CITY OF ALBUQUERQUE

October 17, 2016

**RE: NM Mutual Home Office
Grading and Drainage Plan
Engineer's Stamp Date 9-9-2016 (File:B18D021)**

SHEET TITLE  
GRADING PLAN

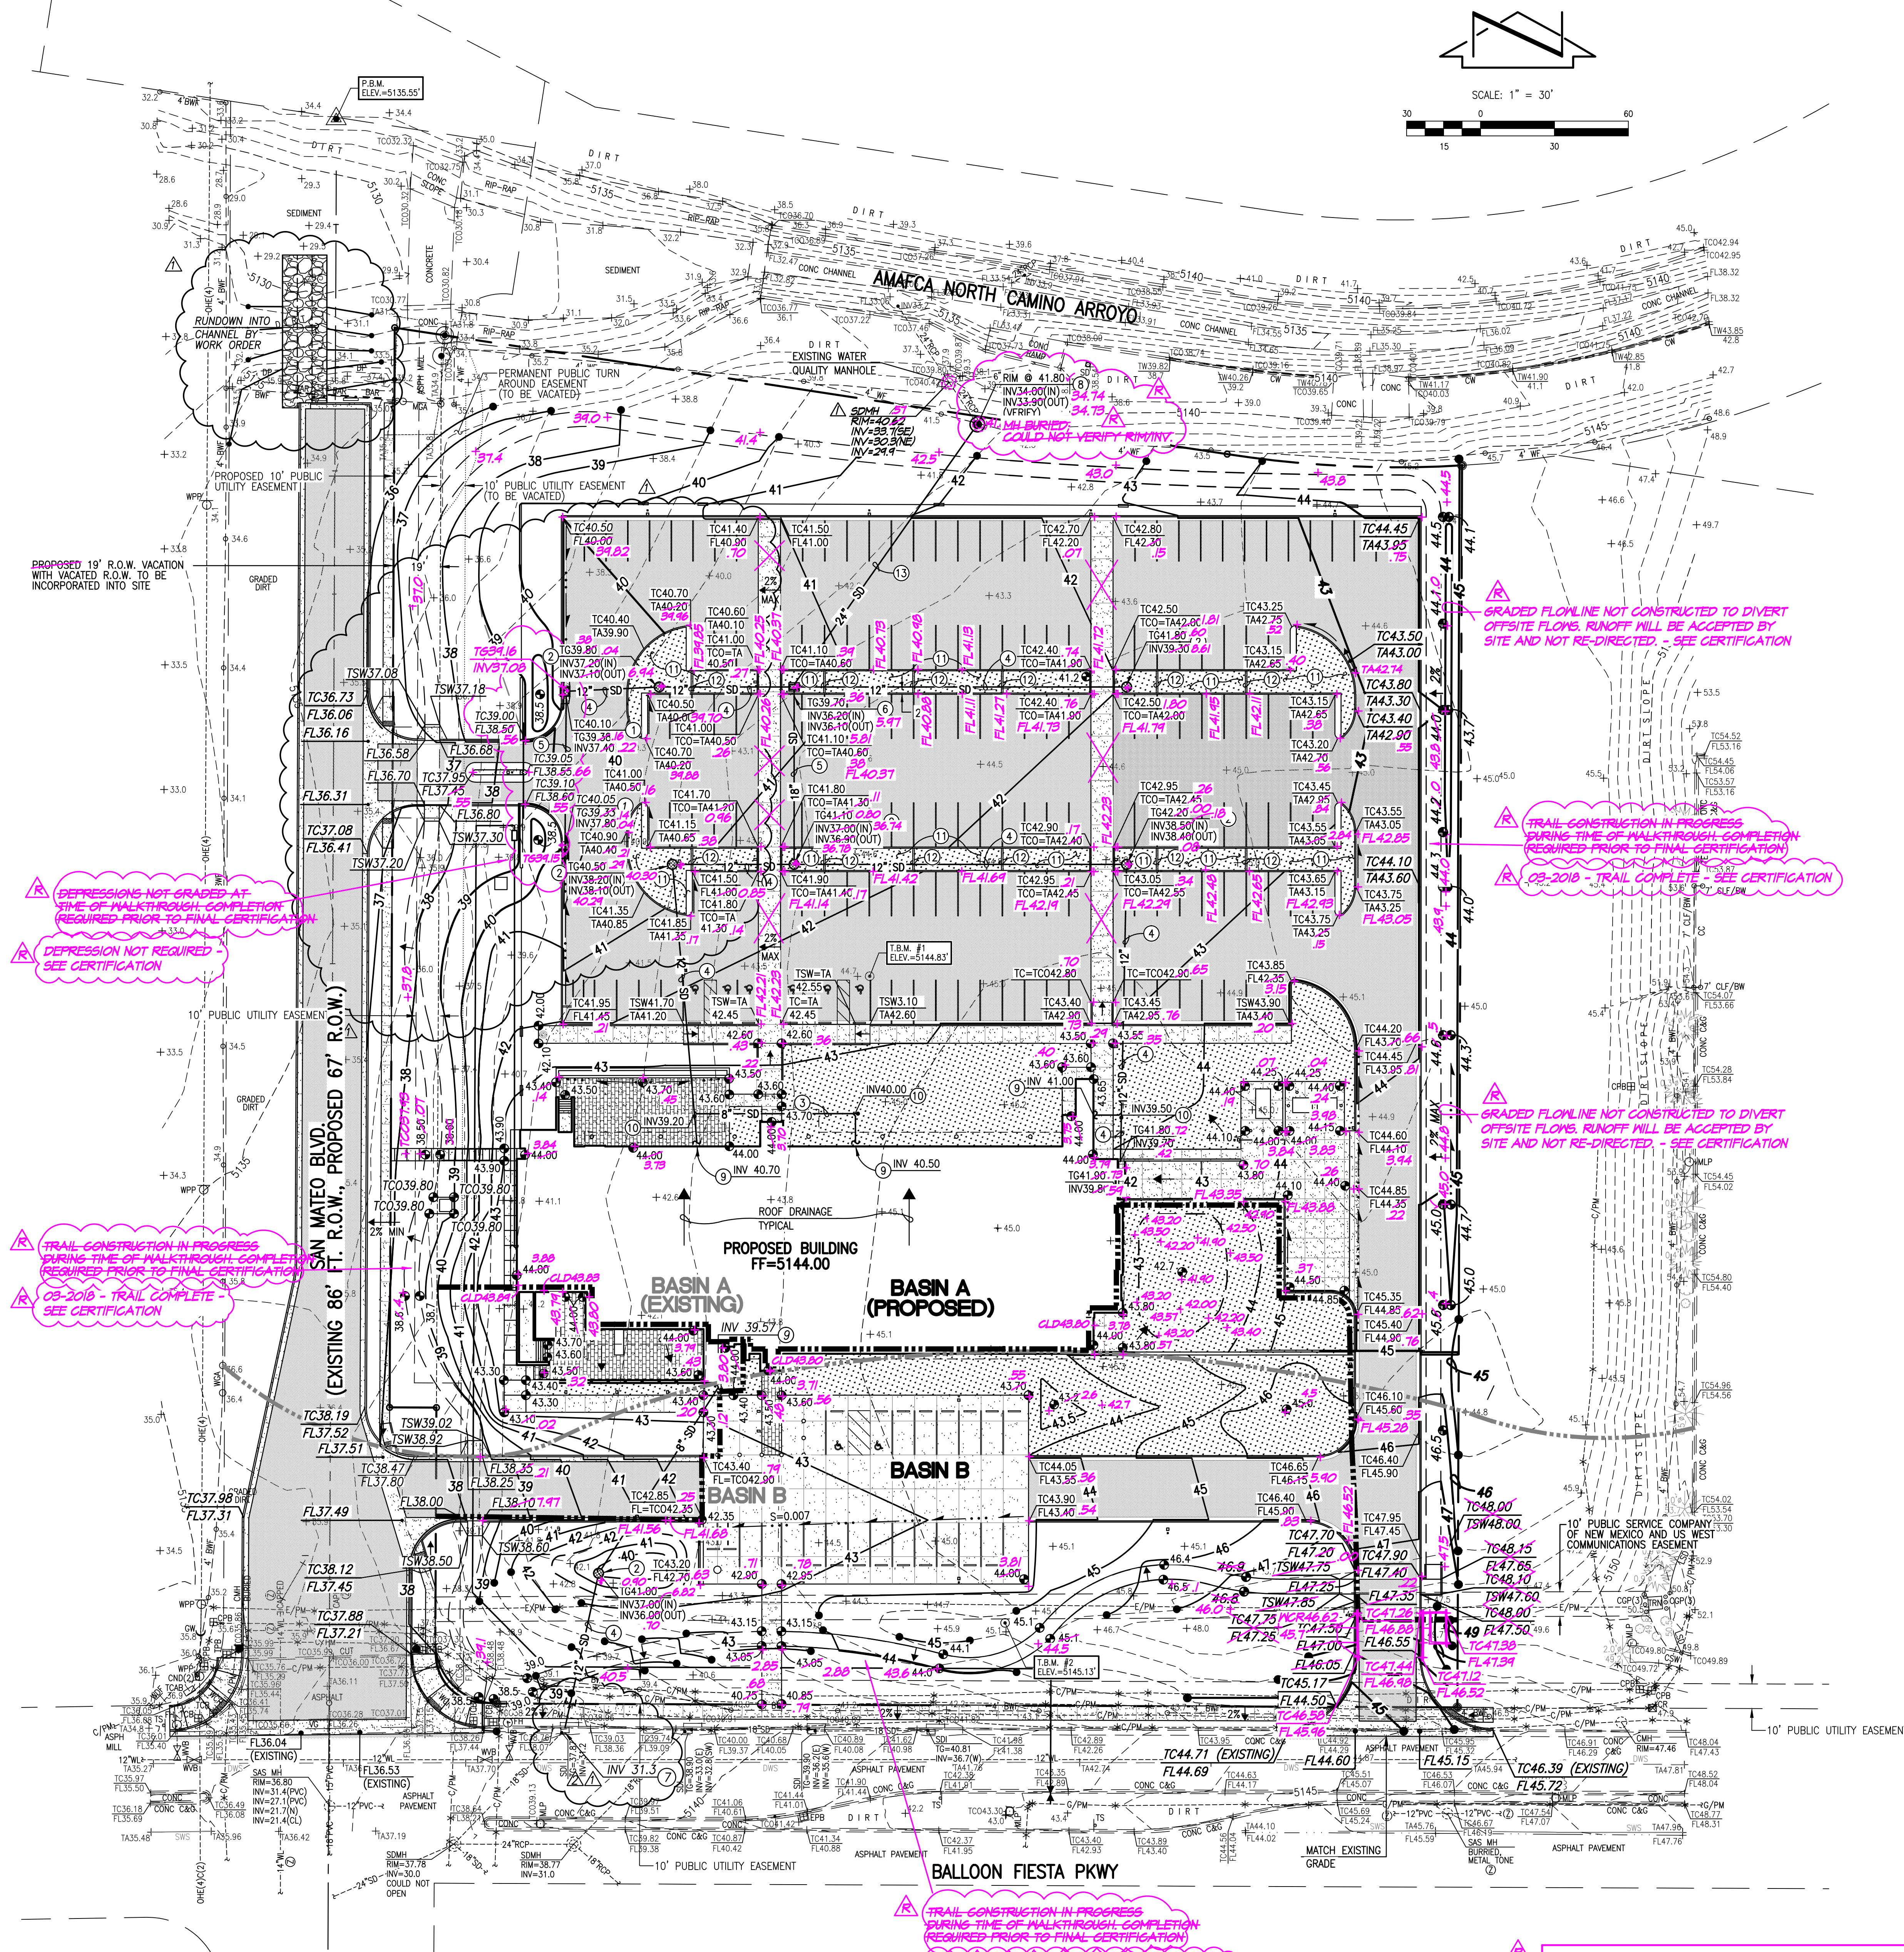
When submitting the certification, make sure the Drainage Narrative and the Calculations for Basin A match, there appears to be a minor discrepancy.
